Approval of details reserved by condition imposed under BE/84/20/PL relating to conditions 3-as built drawings of implemented SuDS scheme & 5-updated copy of management manual or confirmation that no changes are required to manual.

Land At Angels Nursery Yapton Road Barnham PO22 0AY

Arun District Council have decided to **REFUSE details reserved by condition for the following reasons:**

The information submitted regarding Condition 3 imposed on planning permission BN/84/21/PL: relating to the as-built drawings of the implemented SuDS scheme together with a completion report is refused and the condition is hereby not discharged for the following reasons:

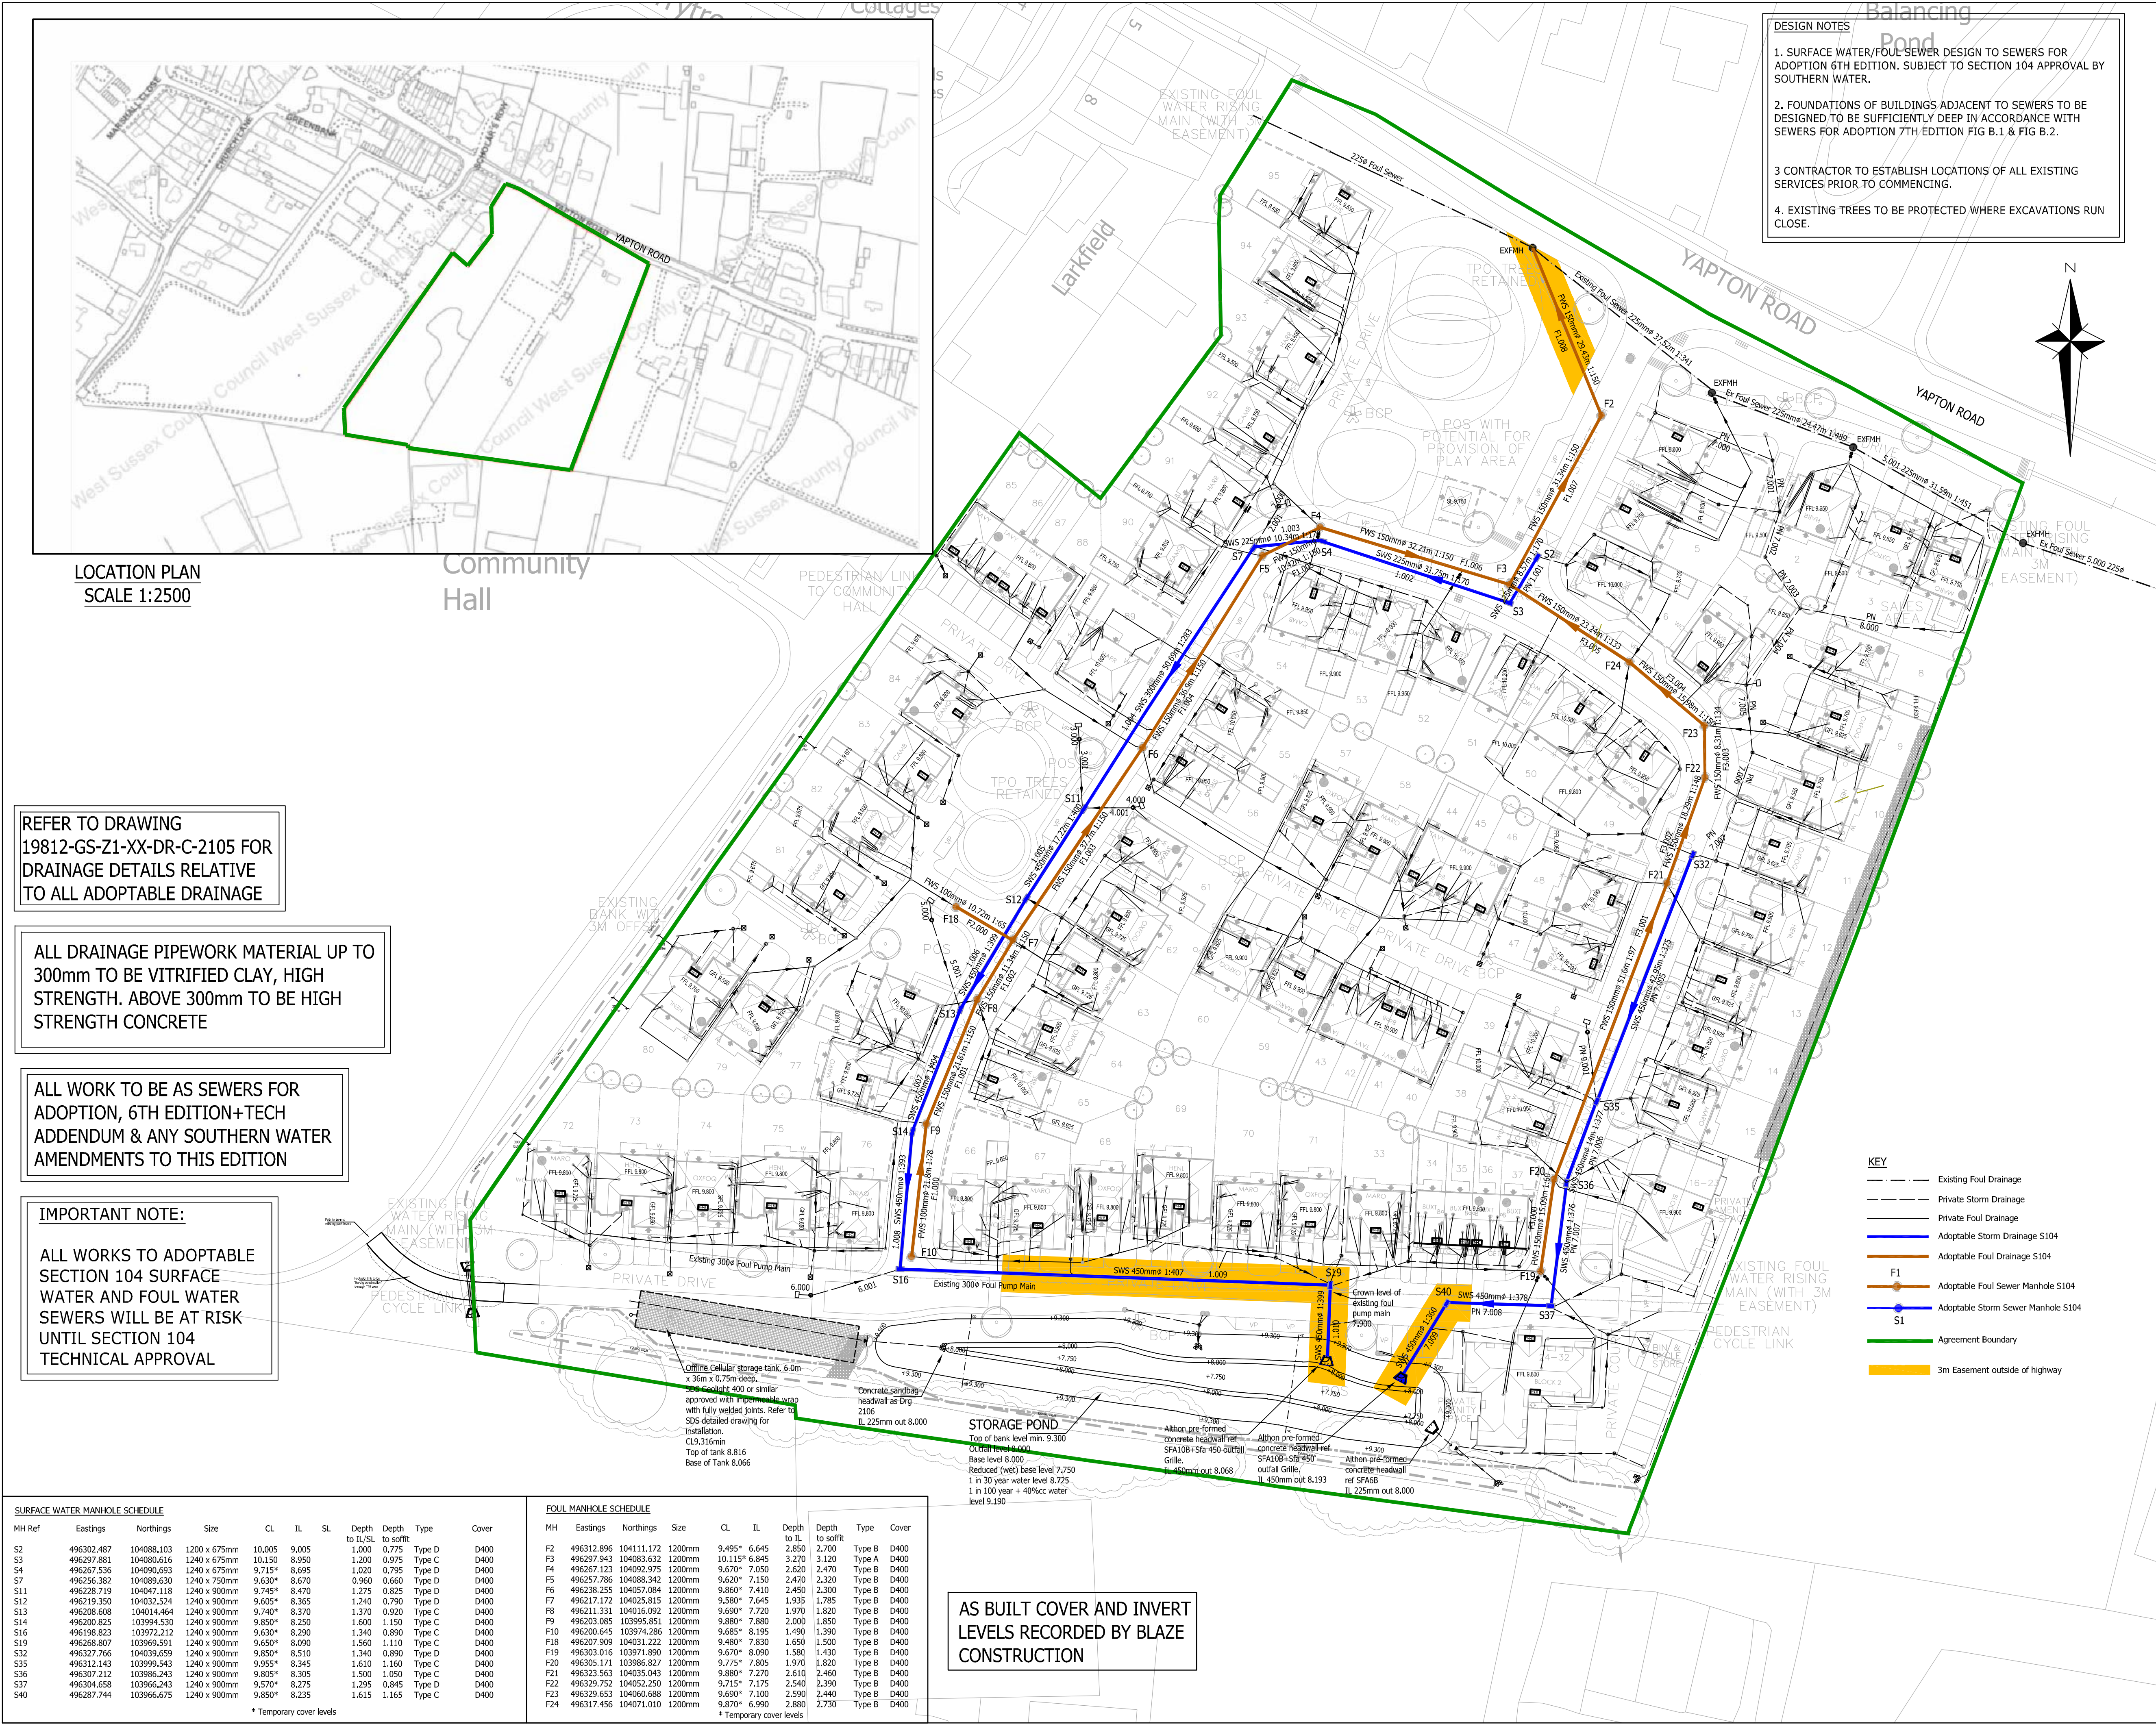
2. Fully detailed as built layouts have not been submitted of all required surface water drainage elements.
3. The verification report fails to include comments upon any discrepancies between as-built survey and design.
4. The verification report fails to include details of any remedial works as a result of CCTV survey.
5. The land drainage consent works have not been signed off; the district engineer has not been invited to inspect the works.
